From: Zac Denton
Sent: 24 July 2019 08:25
To: Planning Scanning
Subject: FW: Mistletoe Farm, Horsemere Green Lane. CM/13/19/RES; Revised Drainage Proposals

Drawing Title				
Engineering Details Drainage Strategy (with Ditch)				
Drawn	Checked	Scales	Paper Size	Date
KN		1:250	A1	07.19
Job No.	Drawing No.	Revision		
ES1820	602-04	C

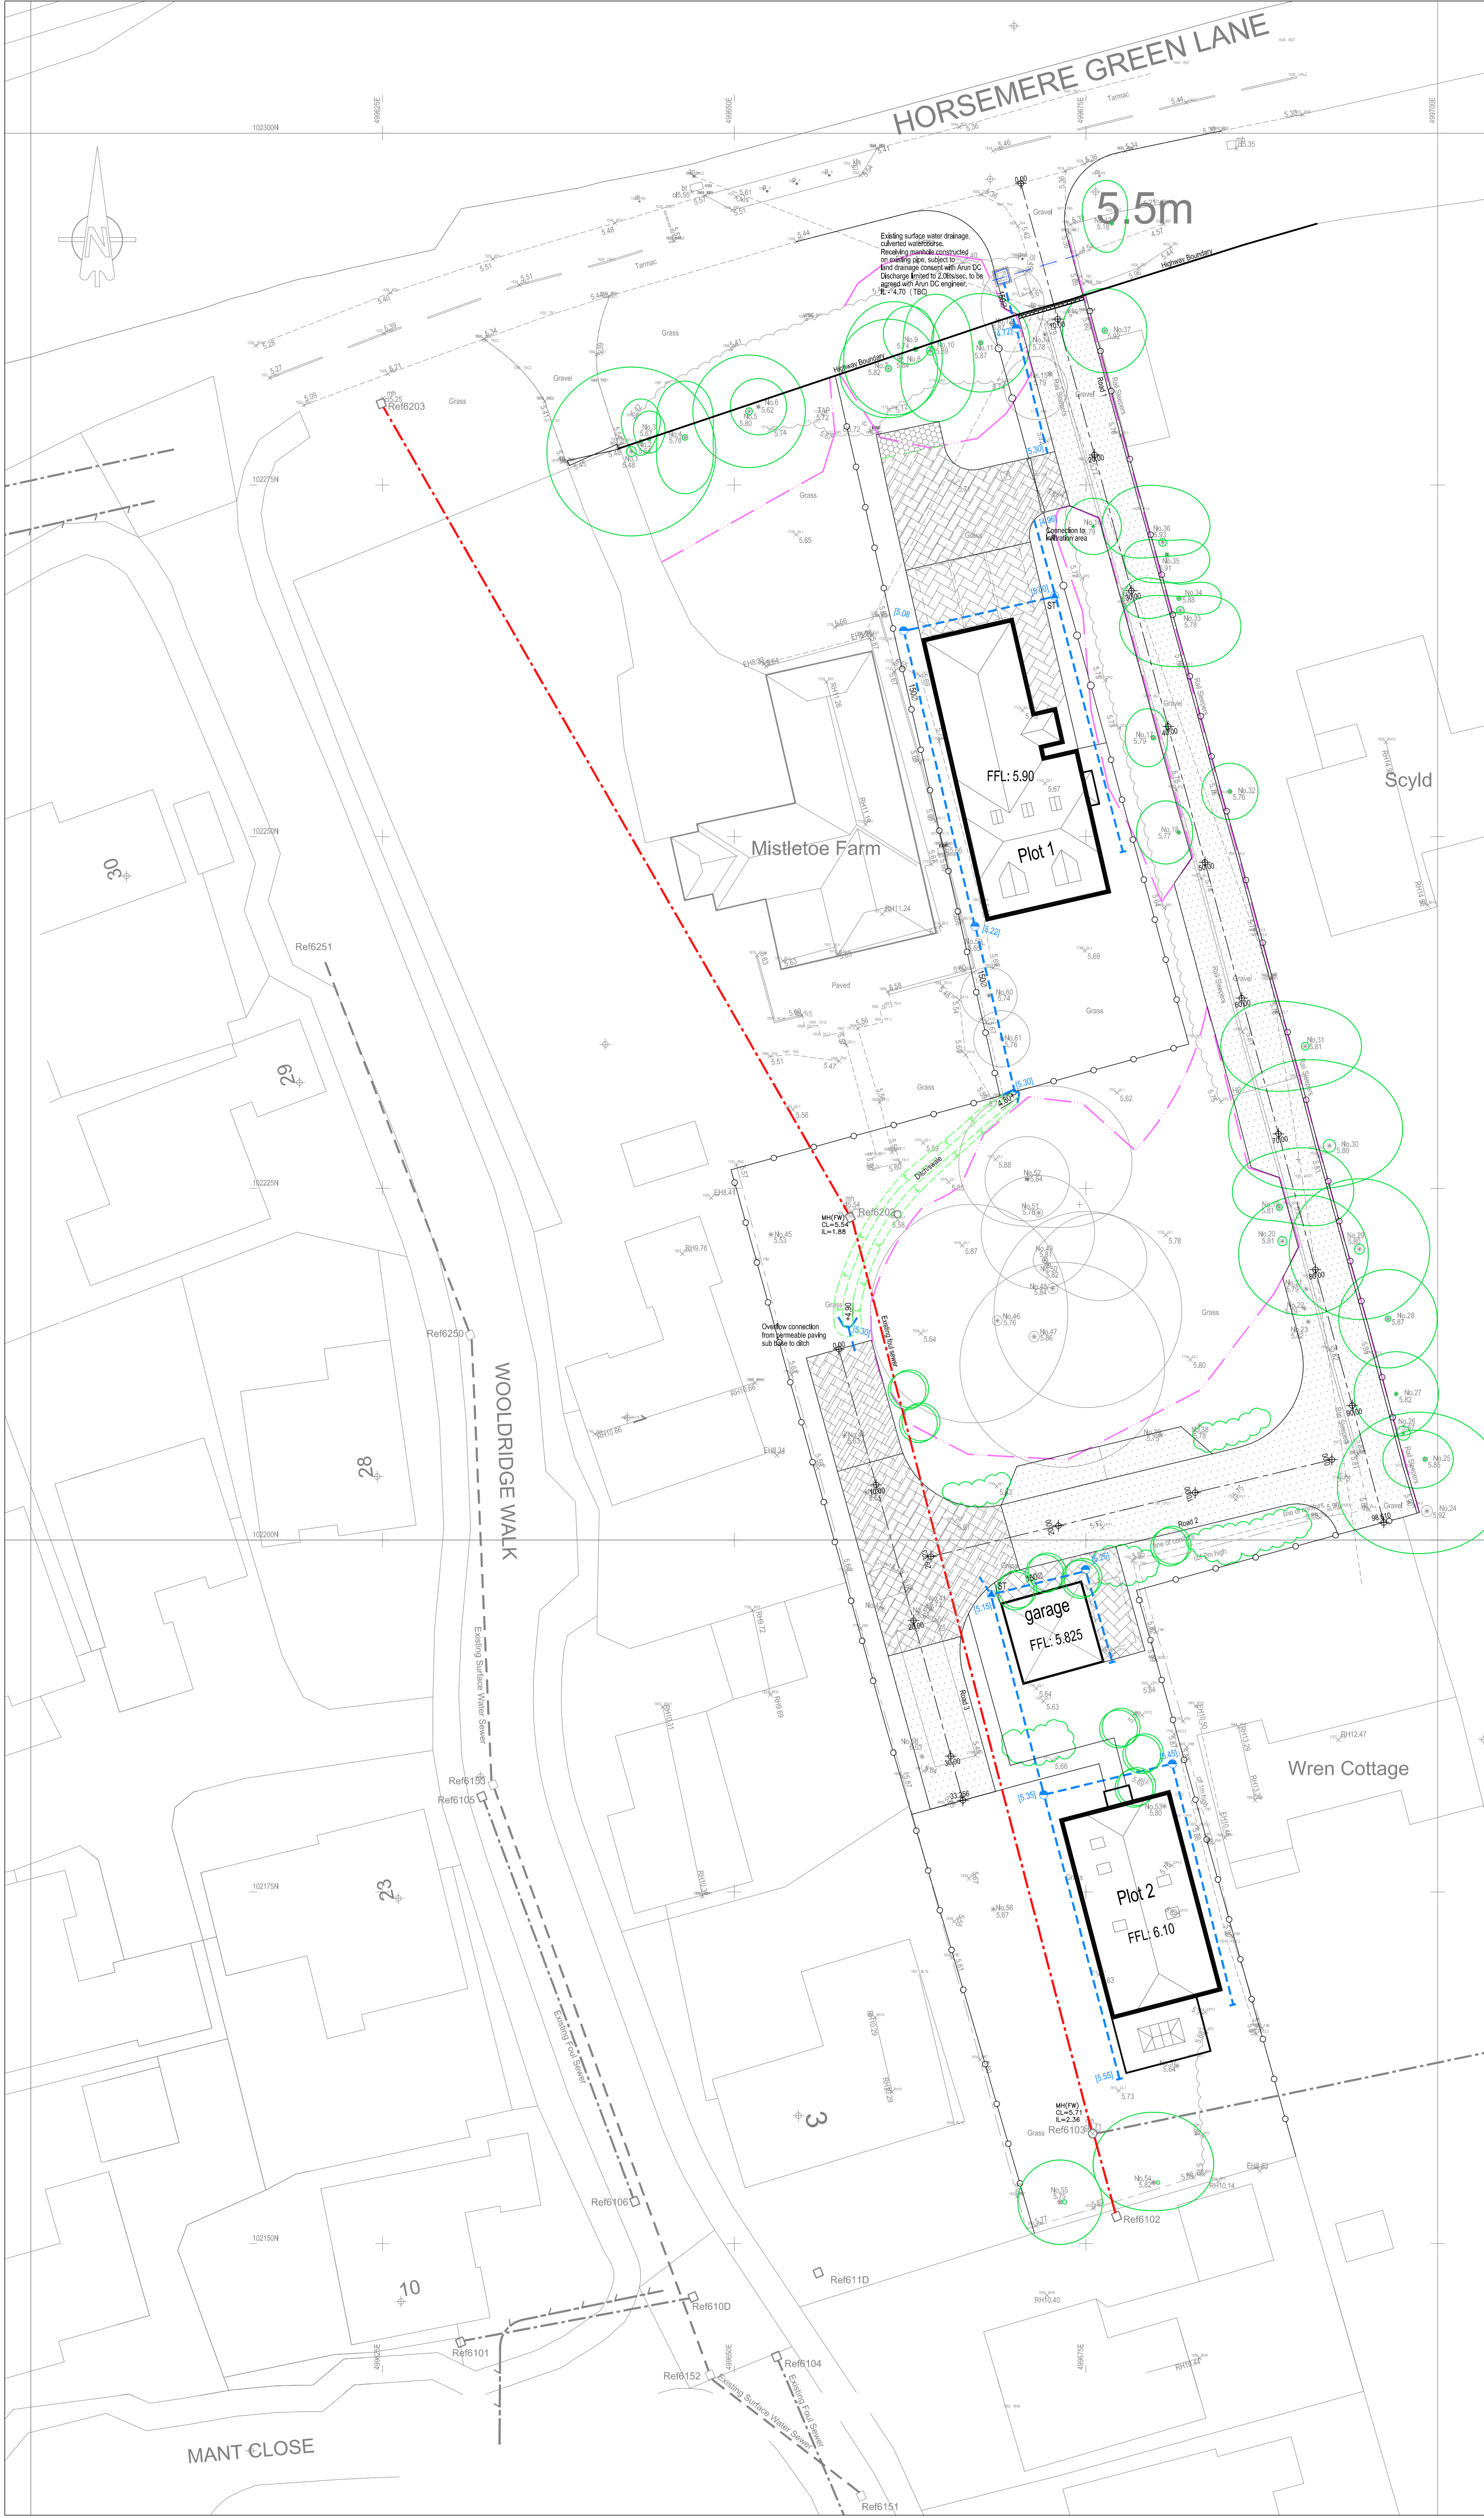
Thank you for sending over the revised plan. I believe there is some conflict between what you are proposing and the tree protection plan (attached).

The permeable paving for plot 2 looks like it could only be located in the T furthest round on the road rather than at the junction of roads 1 and 2. The swale also appears to be within a no dig area.

Thank you for your comments. I was under a misapprehension regarding the RPZ so having cleared that I have put together a revised proposal which addresses your comments on the RPZ. Hopefully you find this revised proposal accords with your thoughts and you are able to advise your planning colleague that we have reached a drainage solution. As always, if you have any further concerns please contact me. Many thanks.
